From: Dulcie Brookfield [REDACTED]
Sent: 08 July 2020 17:15
To: Neil Crowther <Neil.Crowther@arun.gov.uk>; Nigel Lynn <Nigel.Lynn@arun.gov.uk>; [REDACTED]
[REDACTED] Cllr. Henry Jones [REDACTED] Cllr.
Henry Jones <[REDACTED]> Cllr. Amanda Worne [REDACTED] Colin HUMPHRIS [REDACTED]
Subject: SUBMISSION REQUEST: APPEAL AND INQUIRY, INVOLVEMENT OF THE GOVERNMENT OMBUDSMAN - Application ref CM/64/19/PL add CM16/20/PL Langford, Horsemere Green Lane, Clymping

CM 16/20/PL and CM/64/19/PL Langford, Horsemere Green Lane, Clymping

Plot 8 deliberate misrepresentation by applicant MJH Homes to ADC

Drawing Title:
SITE LAYOUT

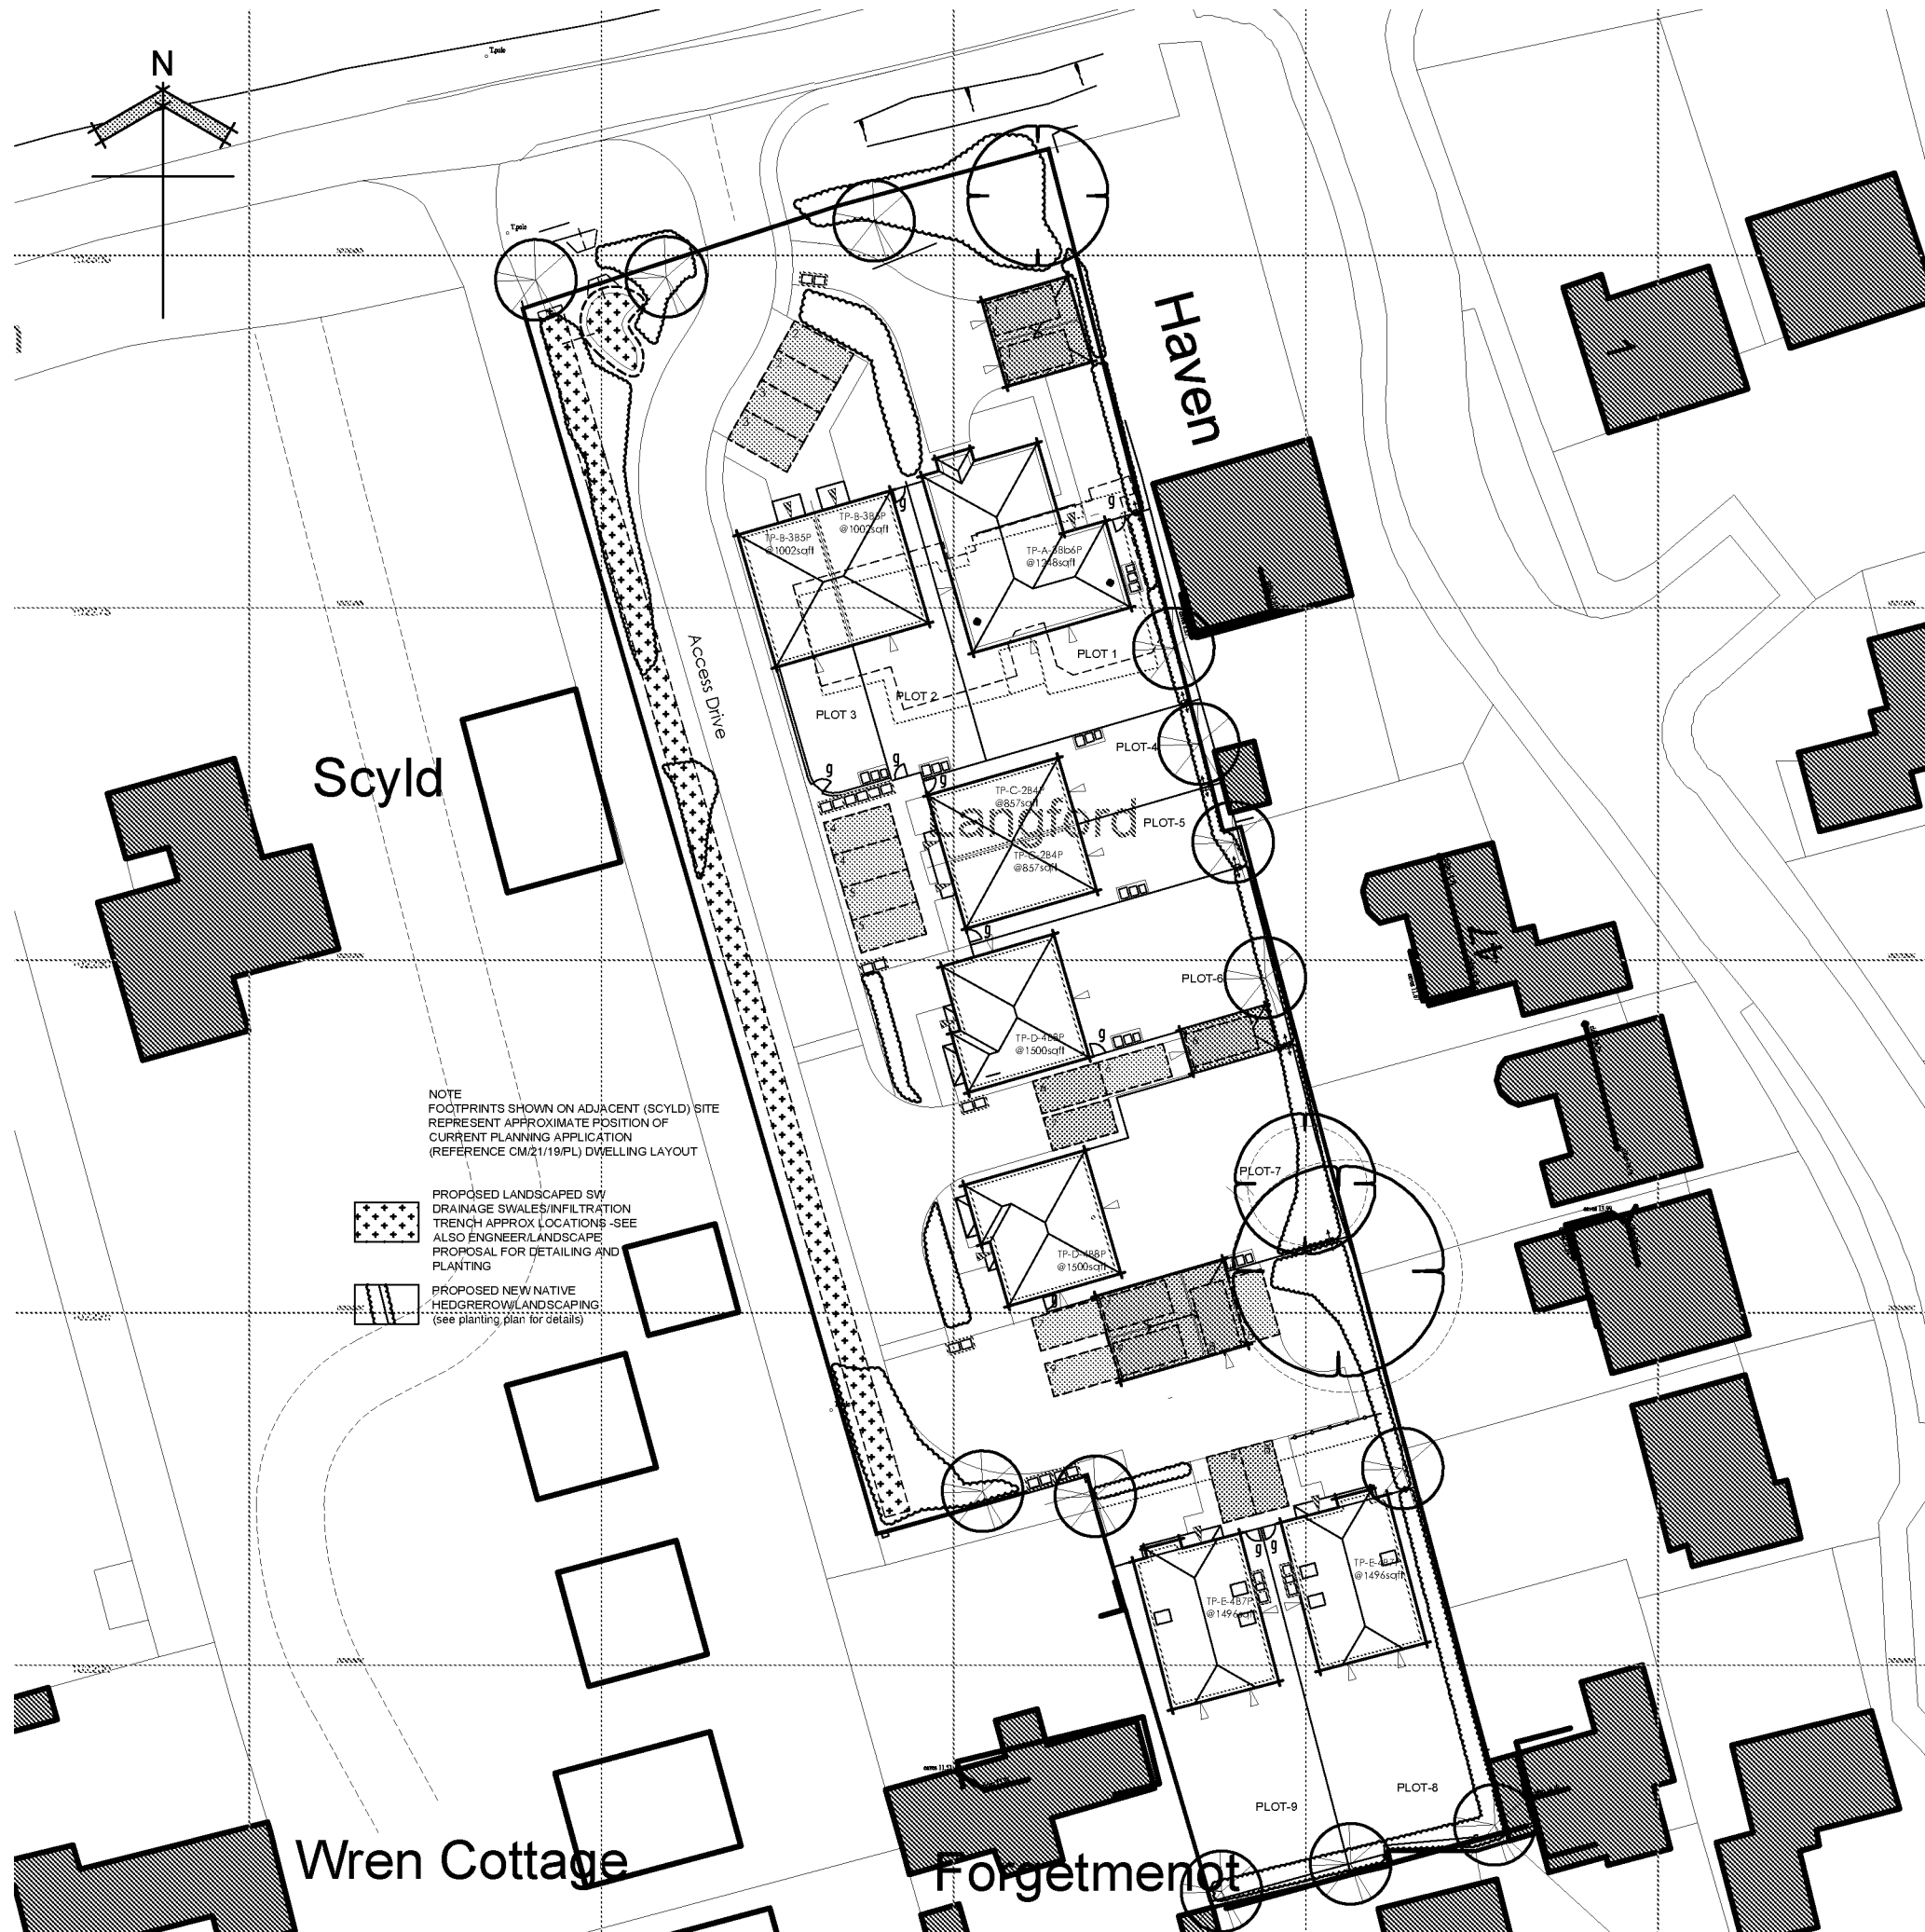
The proposed road and footpath leading to Plot 8 and back fences of existing residents

Highways impact – public road and footpath ending at existing residents back garden fence.

Nowhere on the whole estate does a new road and footpath end at someone's back garden where no path/ easement etc existed previously. This is a very obvious and very real security risk for the existing residents at numbers 44, 45 and 46 Appletree Walk. We should have been officially notified in writing by the relevant Council departments and Highways Agency notified that this was happening. At no point have we been given opportunity to object. Therefore, I submit that the Council has been negligent. If we had ever been consulted, we would have vehemently objected.
